In reply refer to: Ben Davidson 4 Lot Short Plat

BPA Reference: Covington-Grand Coulee corridor
{Str 32/3 on Schultz-Echo Lake line}

The Bonneville Power Administration (BPA) has received the proposed short-plat of your 21 acre parcel in the Easton, Washington area. Your plat is located in the SW $\frac{1}{4}$ SE $\frac{1}{4}$ of Section 19, Township 20 North, Range 14 East, Kittitas County, Washington as generally shown on the attached portion of BPA Drawing 153729, which I have included for your reference.

BEN DAVIDSON REVISED 4 LOT SHORT PLAT

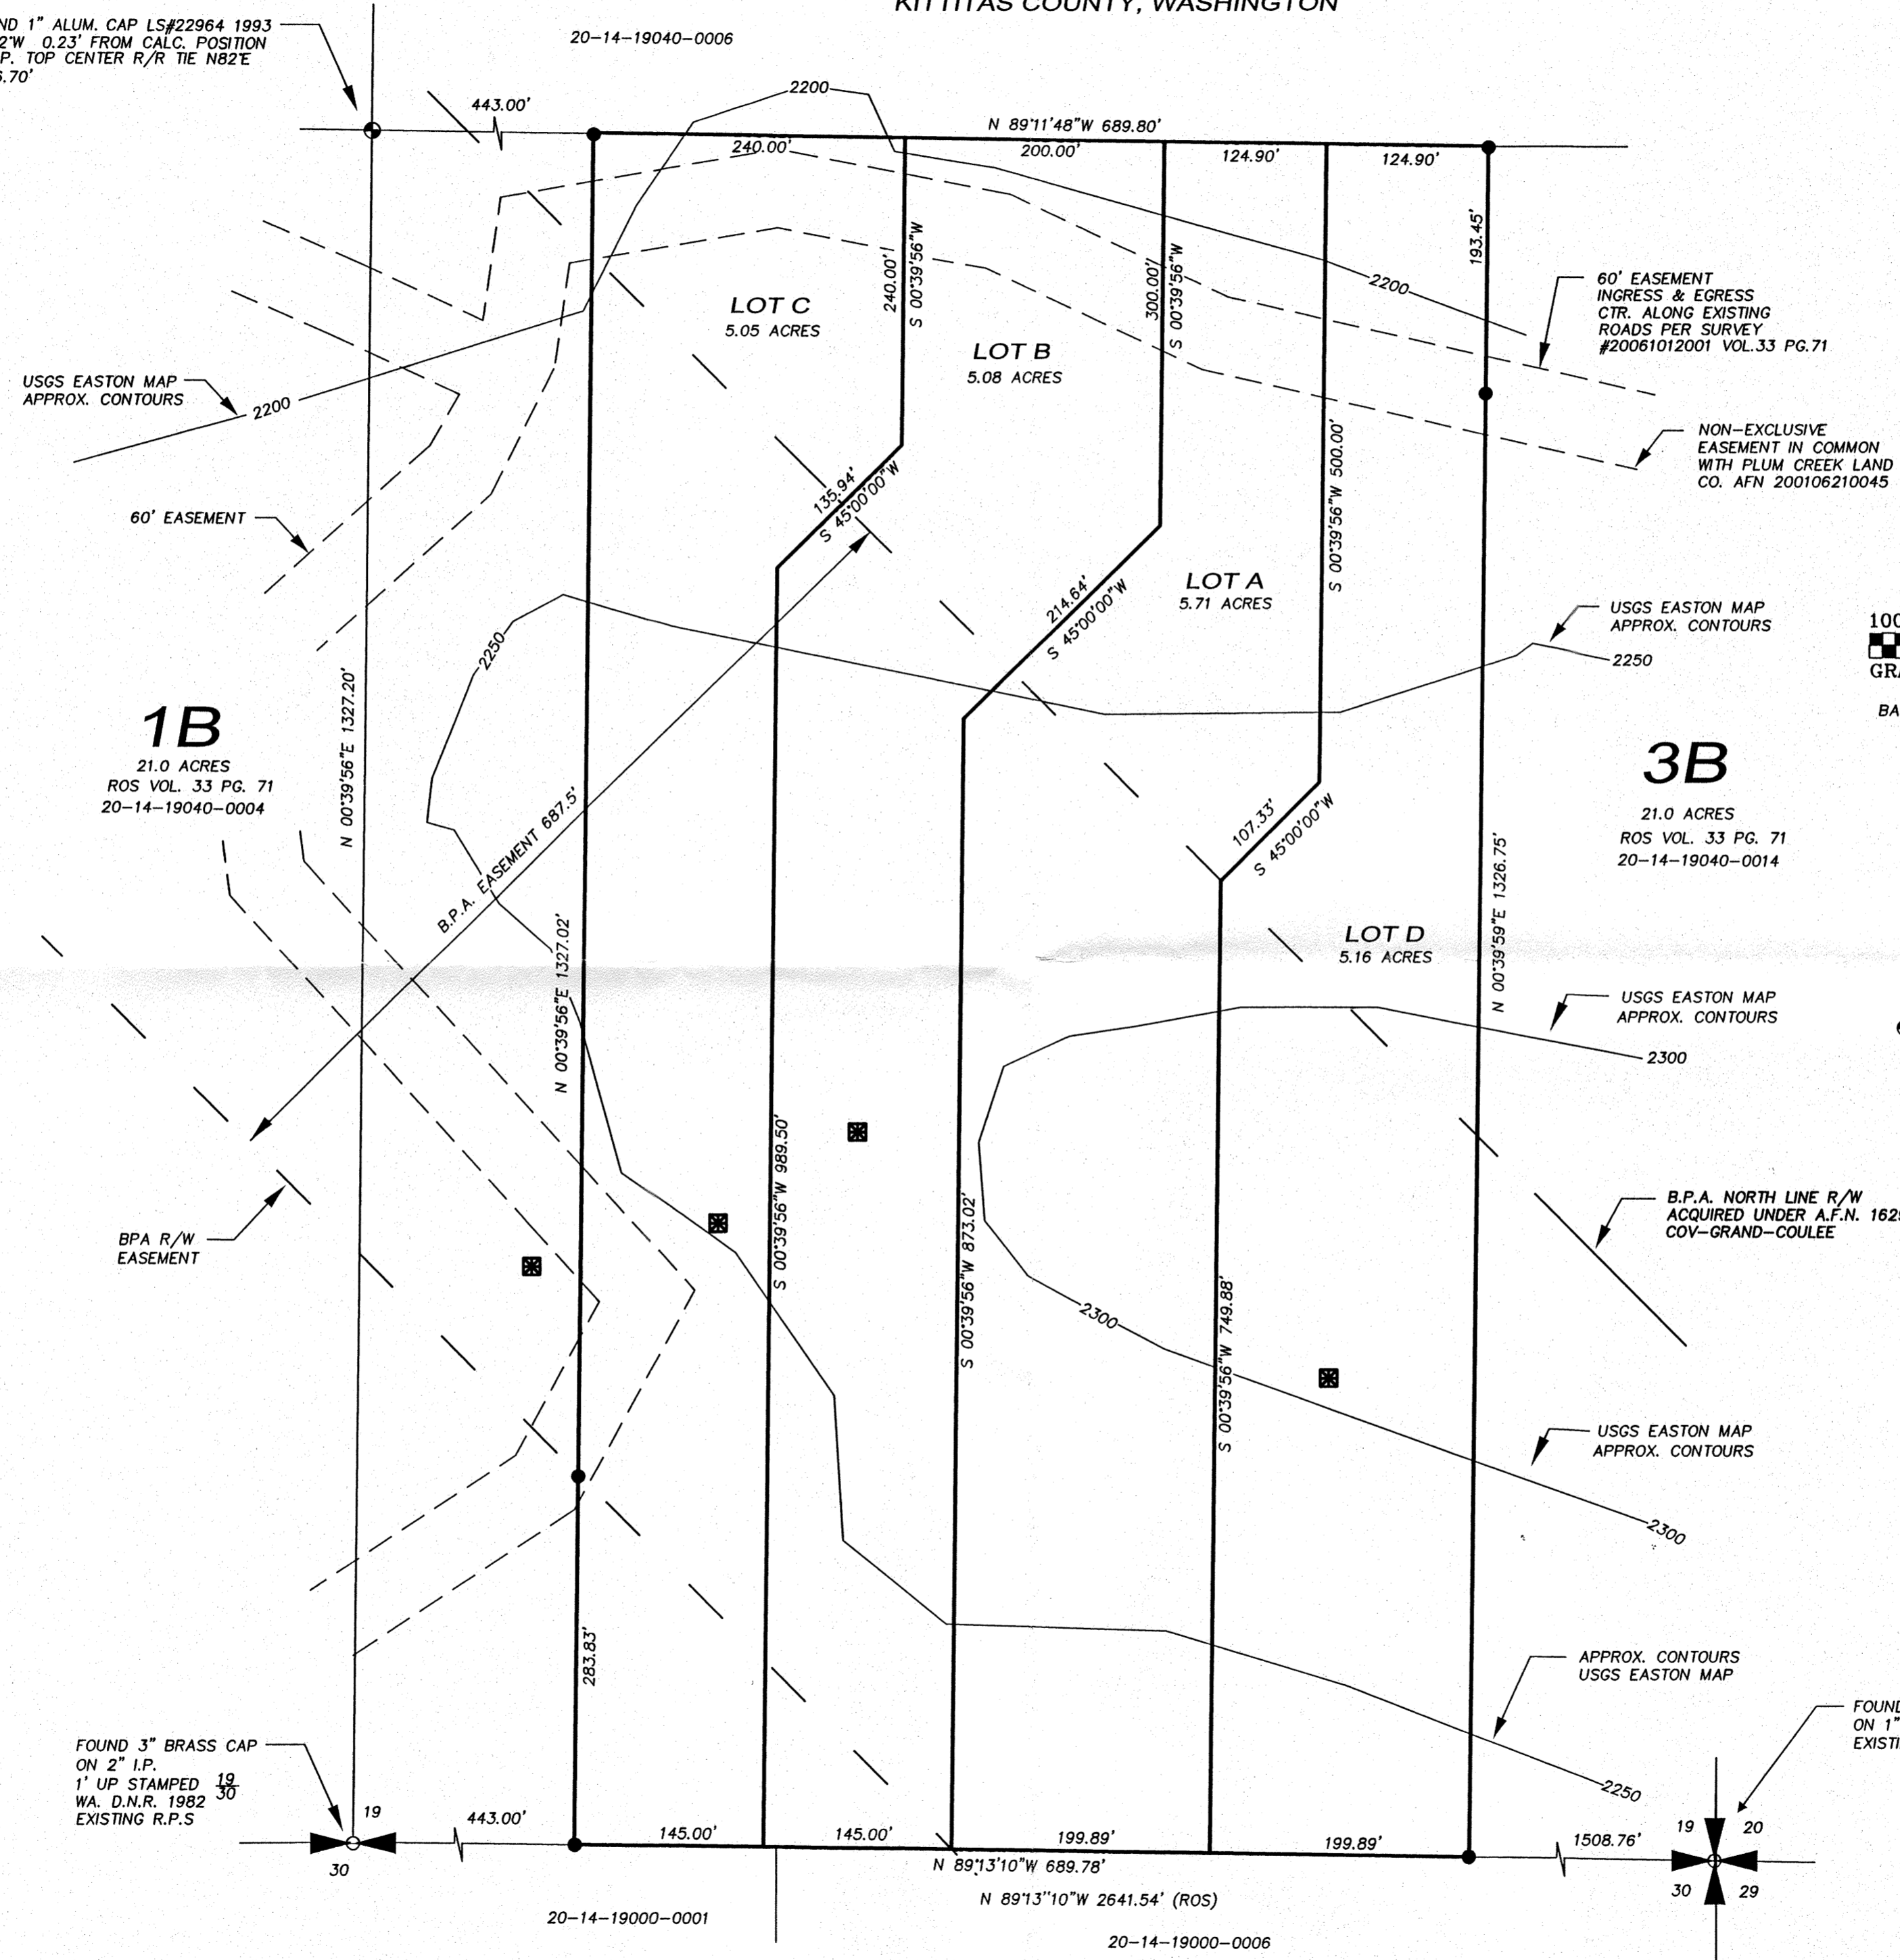
In researching our lines in this area, it appears that BPA has a 687.5'-wide transmission line corridor which impacts your proposed plat (your plat indicates only 300'). Quite a few items immediately jump out at me as something that may not be compatible with BPA's use of this corridor for our transmission purposes and I have listed them below:

1. BPA easements are taken with certain restrictions on the underlying land. BPA does not allow structures to be built within the right-of-way, nor does it allow access to be blocked to any transmission facilities. The way your proposed lots are laid out, it does not leave a lot of buildable area in any of the lots.
2. Any activities that block maintenance crews, such as the installation of fences, abolishment of on-line access routes, buried items such as drainfields or irrigation systems will need to be addressed prior to installation or construction in order to avoid later modification, at the landowner's expense. Typically we can avoid extensive inconvenience to the purchasers of these lots by adding the following statement to your plat when the final version is approved and recorded.

3. On your proposed plat, you have listed a 60' private utility and access easement along the top portion of Lots B & C. Unfortunately, BPA cannot guarantee that utilities will be allowed in this area as they may not be compatible with the transmission lines in this area. This utility route would need to be approved by BPA prior to BPA approving your proposed plat. I only see where it is listed at the top of these lots, and will need to know if the proposed utilities extend out in other places within the corridor.
4. You show a proposed well approximately 75' from the Schultz-Echo Lake structure 32/3. BPA will not consider any wells unless they are a minimum of 164' from a transmission structure since BPA does weed spraying and typically sprays at structure sites. This minimum setback requirement is to allow BPA to do our work without adversely impacting any proposed wells.

The Bonneville Power Administration (BPA) imposes certain conditions on the portions of these lots encumbered by its high voltage transmission line right-of-way. BPA does not allow structures to be built within the right-of-way, nor does it allow access to be blocked to any transmission facilities. Prior to installation, BPA needs to agree to any activity that is to occur within the right-of-way. Information regarding the agreement process for proposed uses of the right-of-way may be addressed to BPA Real Estate Field Services toll free at (877) 417-9454.
